# Planning and Development

Date: 12/09/2024

**Site: Stonestreet Green Solar**  
**Proposal: Application for an Order granting Development Consent**  
**Issue: Relevant Representation**

**Drawing Title:**  
Illustrative Layout Plan  
Key Plan

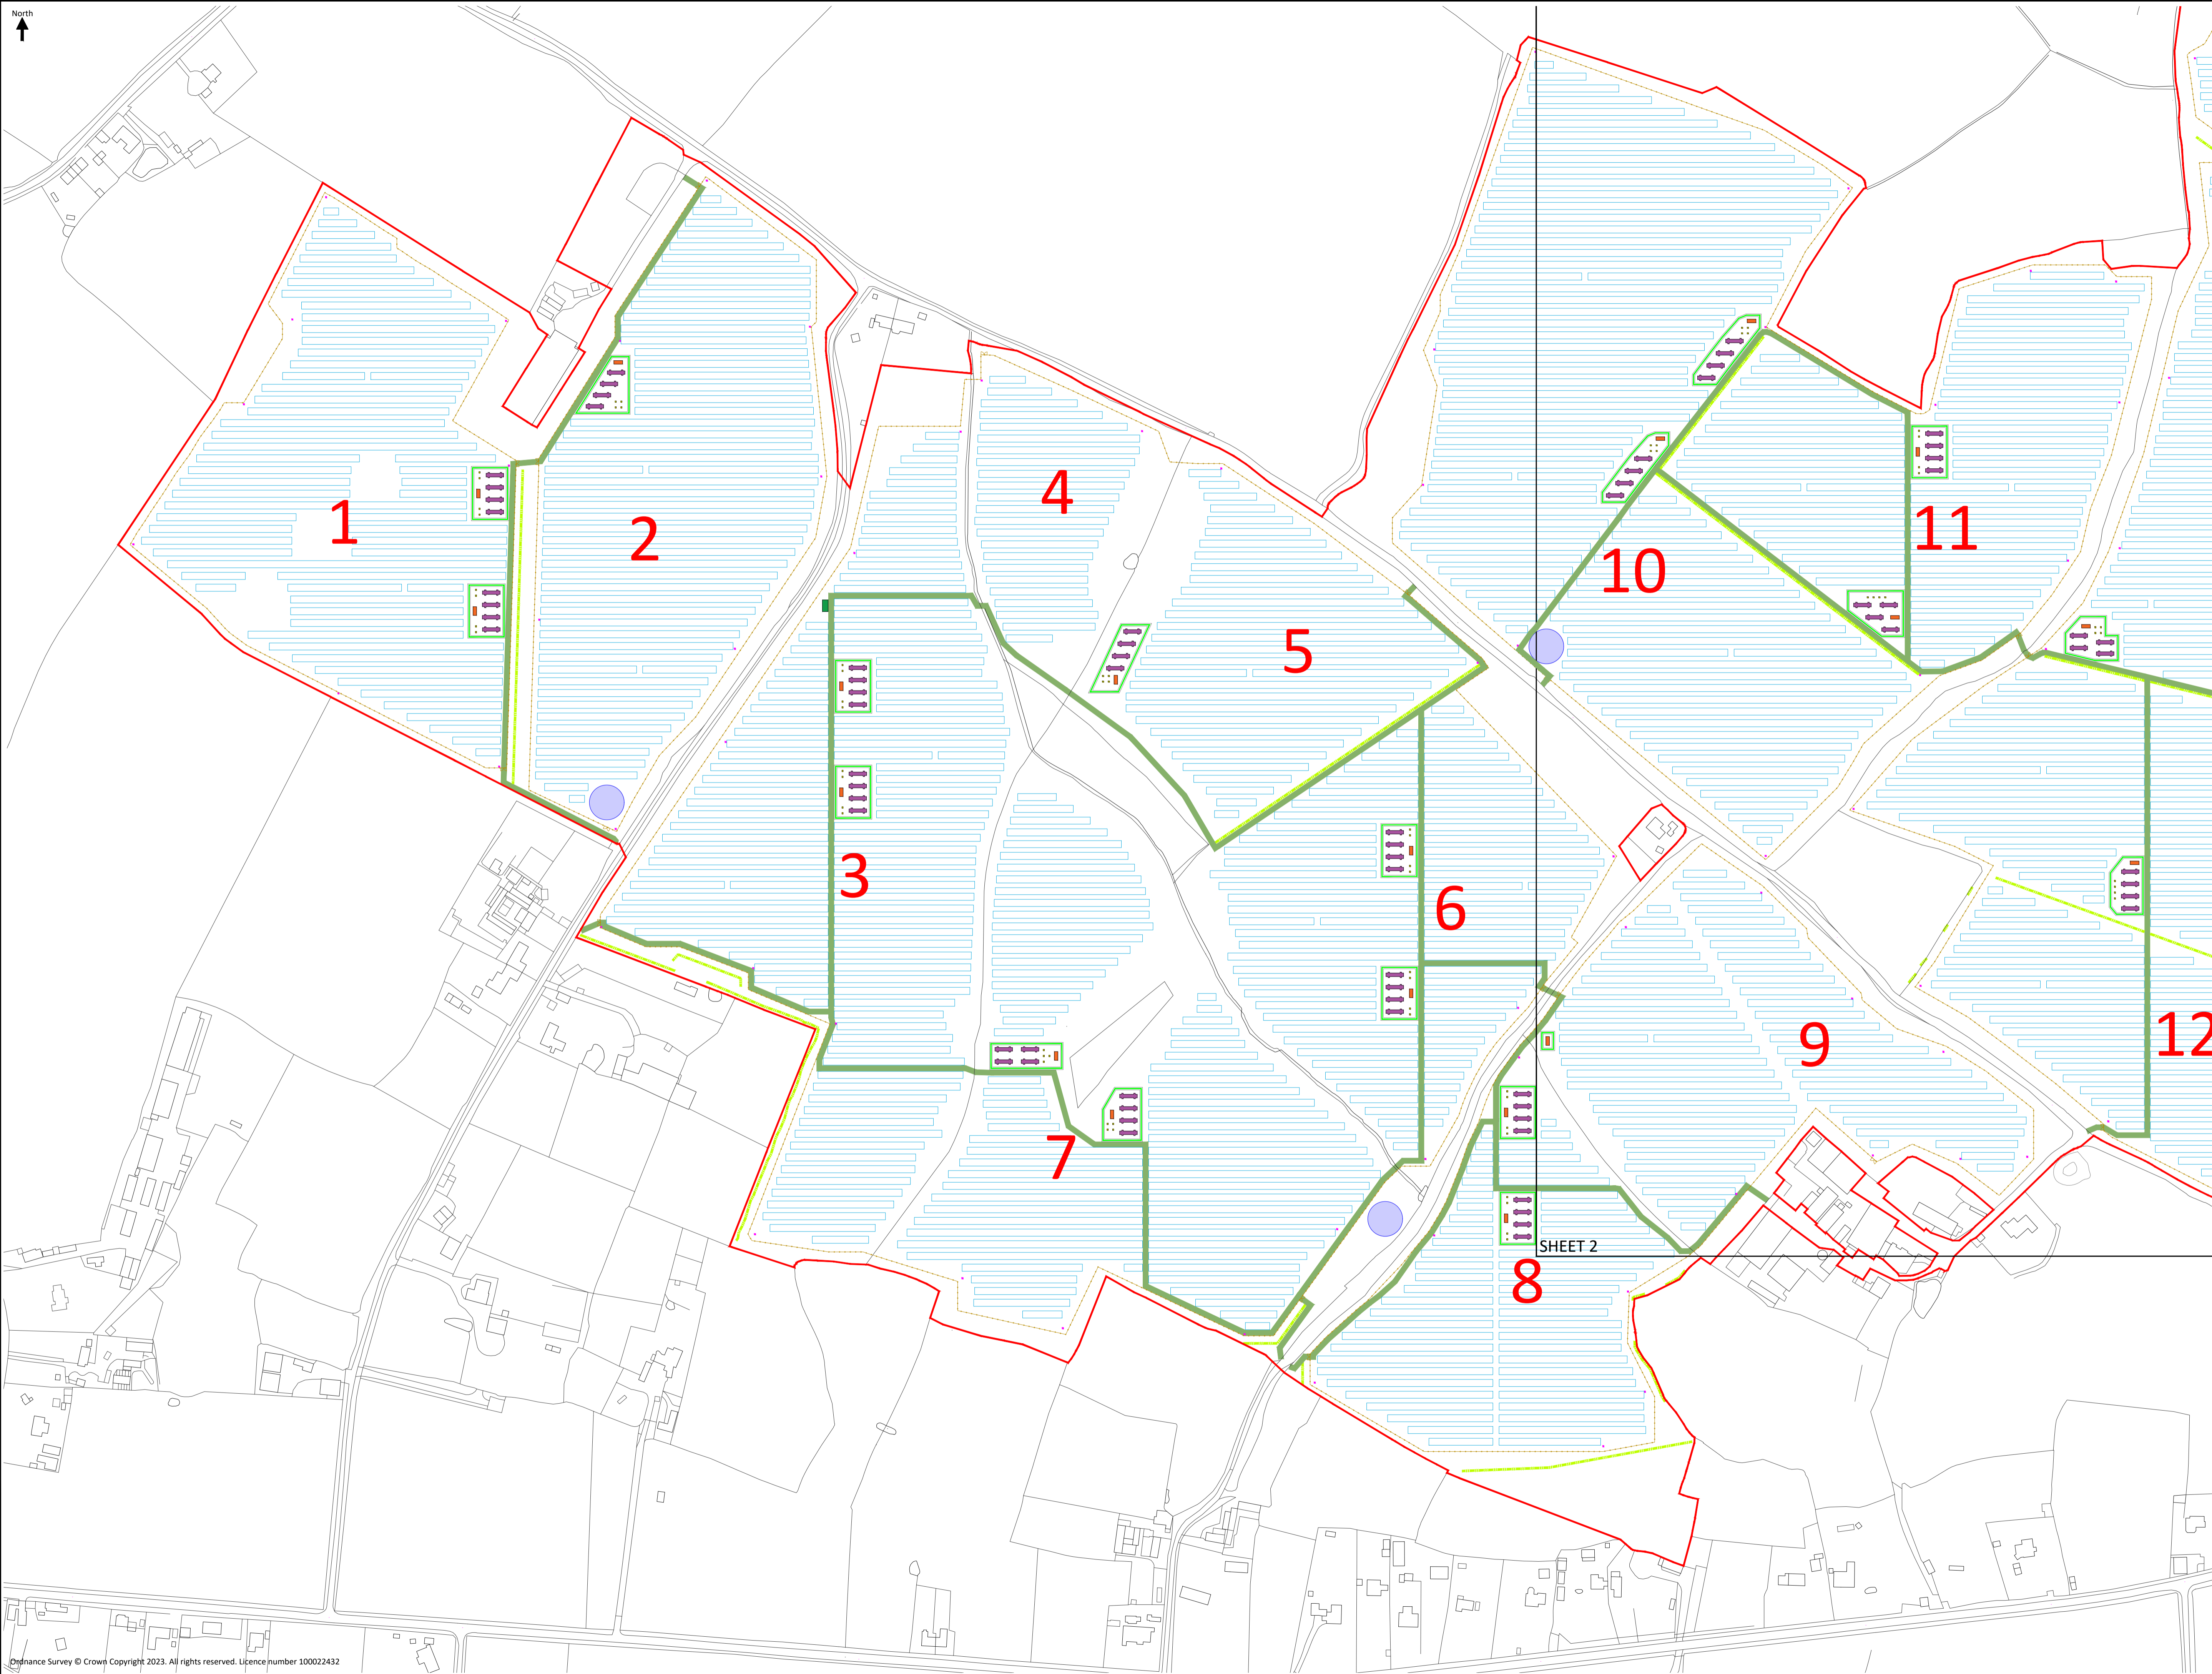
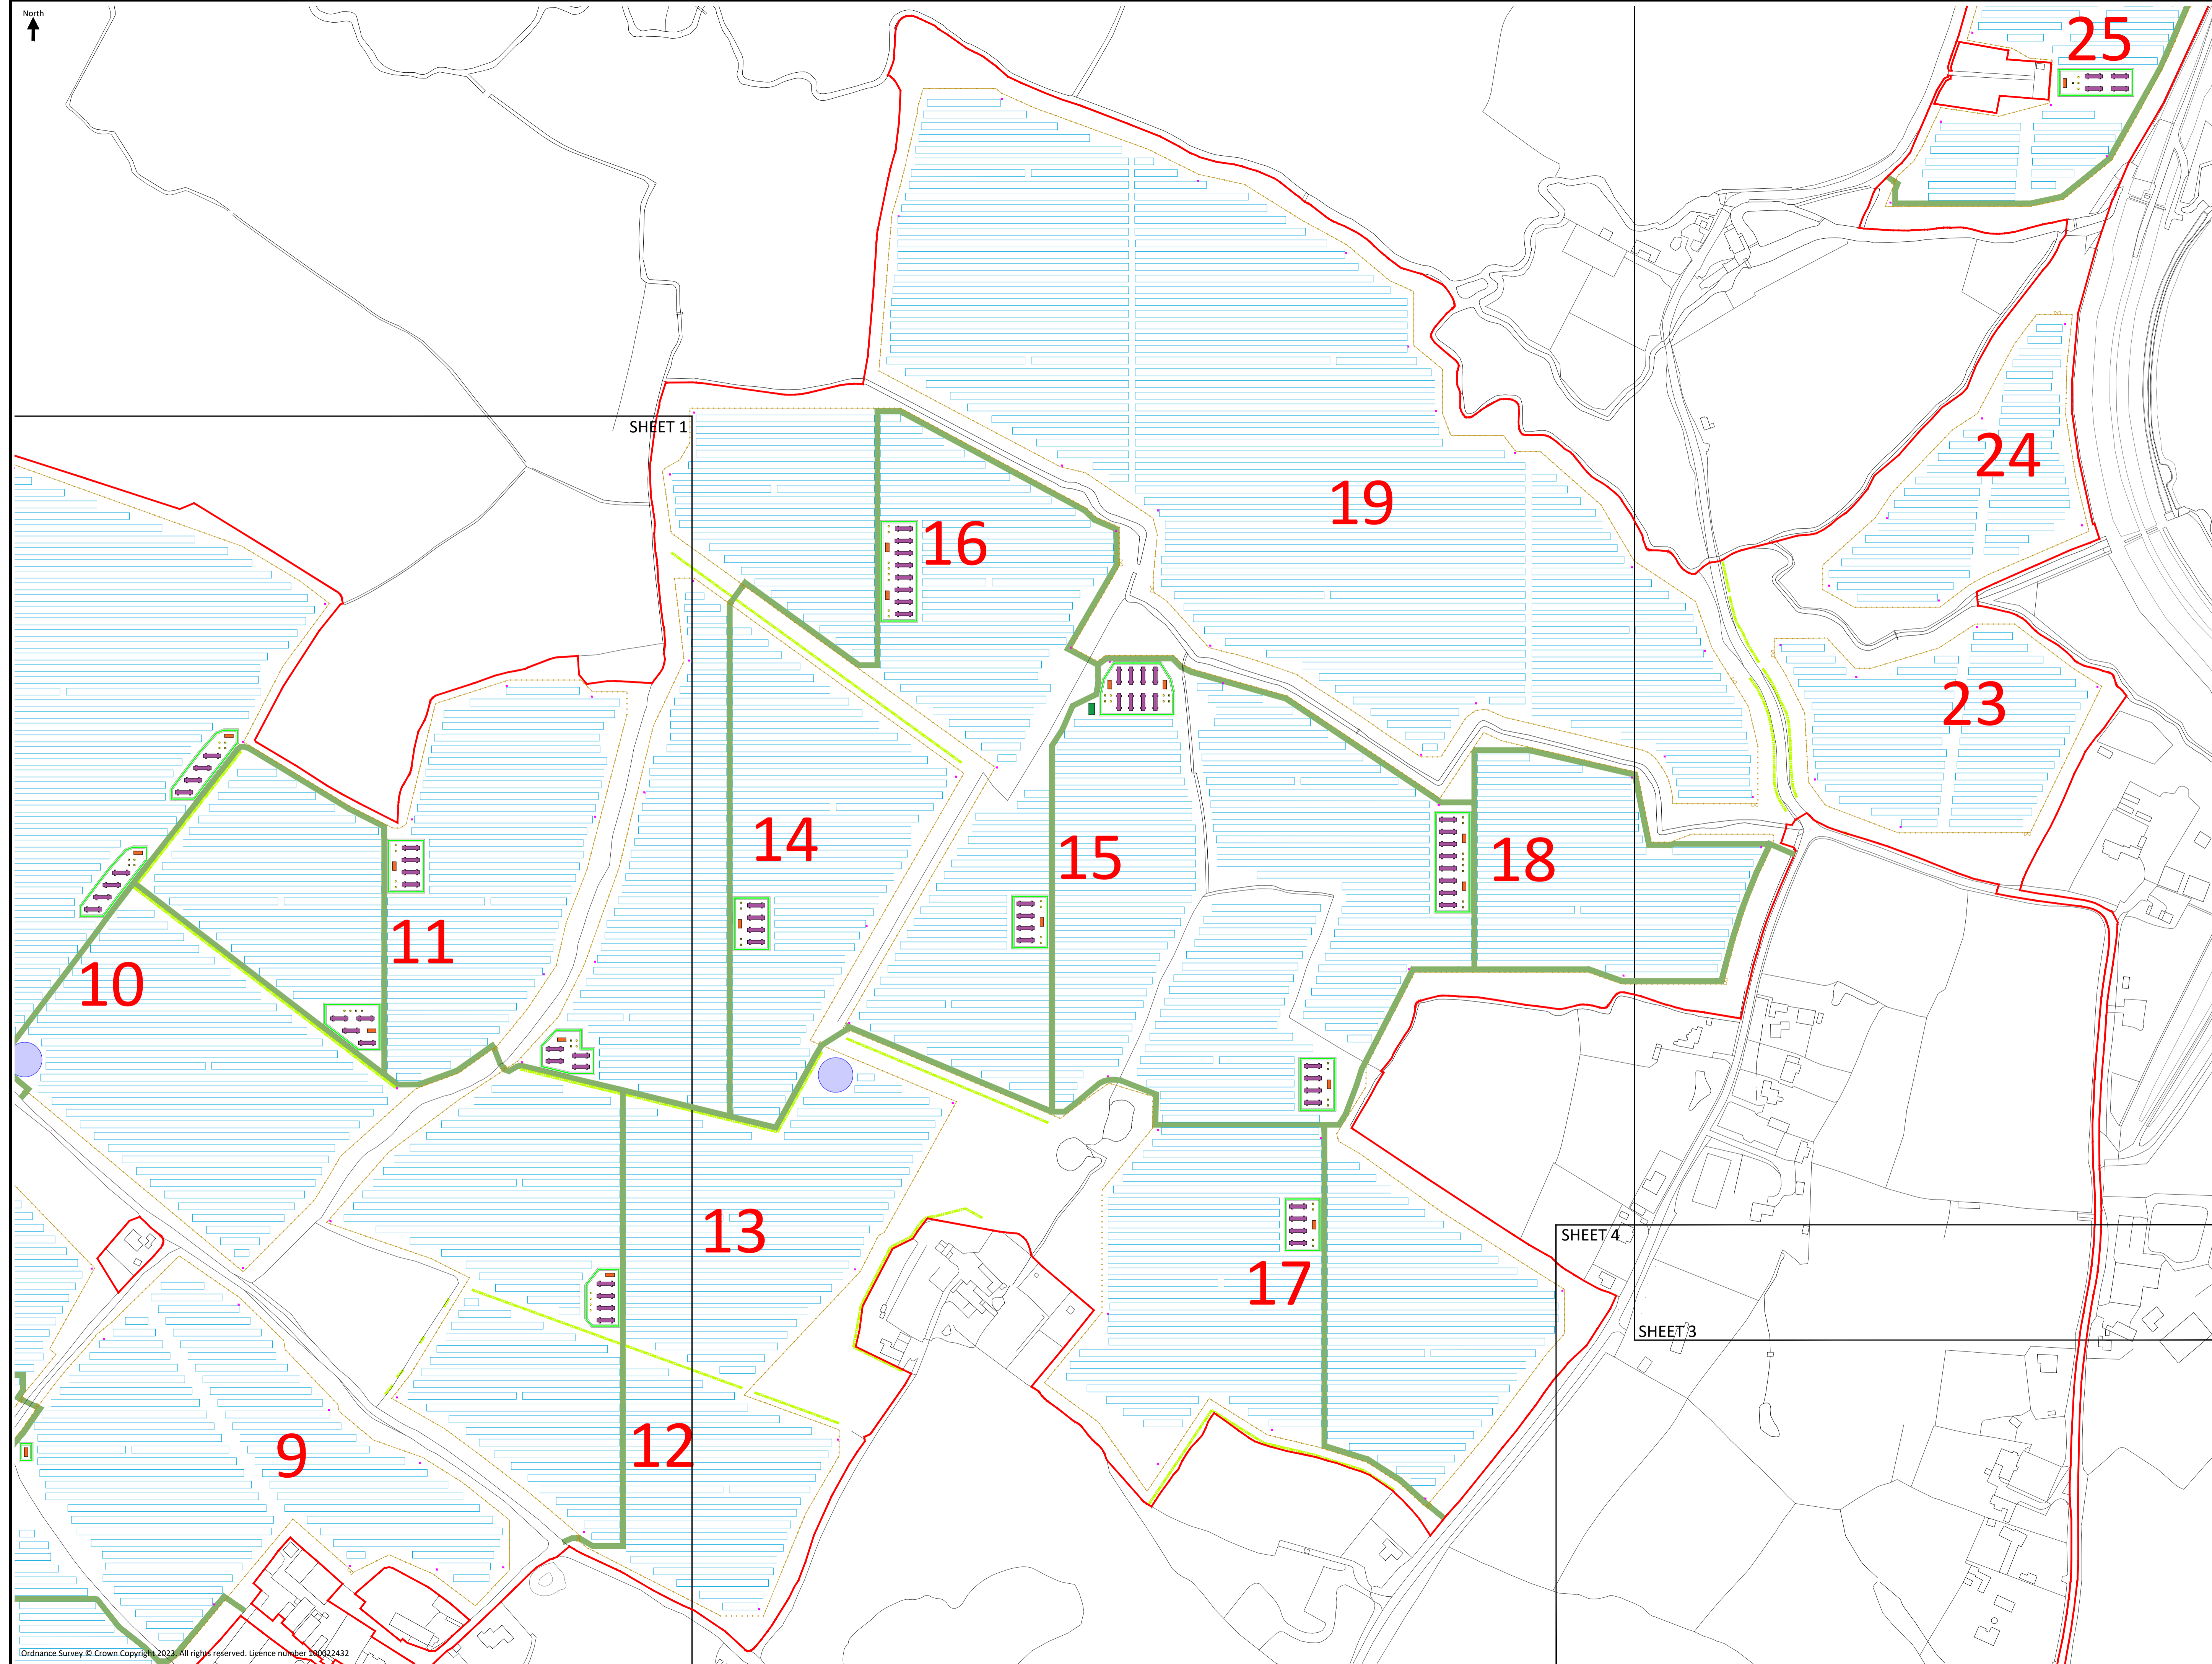
21. The Council consider that tangible material landscape and visual impact benefits would be likely to be achieved if panels were to be removed from fields at higher AOD levels close to this distinctive ridge along which Roman Road / Bank Road passes. The removal of panels from Fields 10 & 12 was therefore suggested to the applicant in this regard.

26. The greater use of tree belts would help break up and reduce the prominence of the mass of panels, in particular in the views that are available from the north. A strong tree-belt on the northern edge of the northern-most Field 19 in this part of the site is appropriate but the Council consider that this needs to work in conjunction with a greater level of new tree planting and associated scheme loosening through fragmentation in the areas south of that northern-most boundary.

of this area is important because the boundary is close to PRow AE474. The Council is concerned that the scheme impacts on the experiential qualities enjoyed by the users of that route. The qualities include the appreciation of a wide area of landscape from a high point as well as a key vista (that includes landscape) towards the Grade 1 listed Church of St. Martin which sits prominently on the east-west Aldington ridge. The Council would wish to see softening and, ideally, solar development and infrastructure pulled further northwards away from PRow AE474.
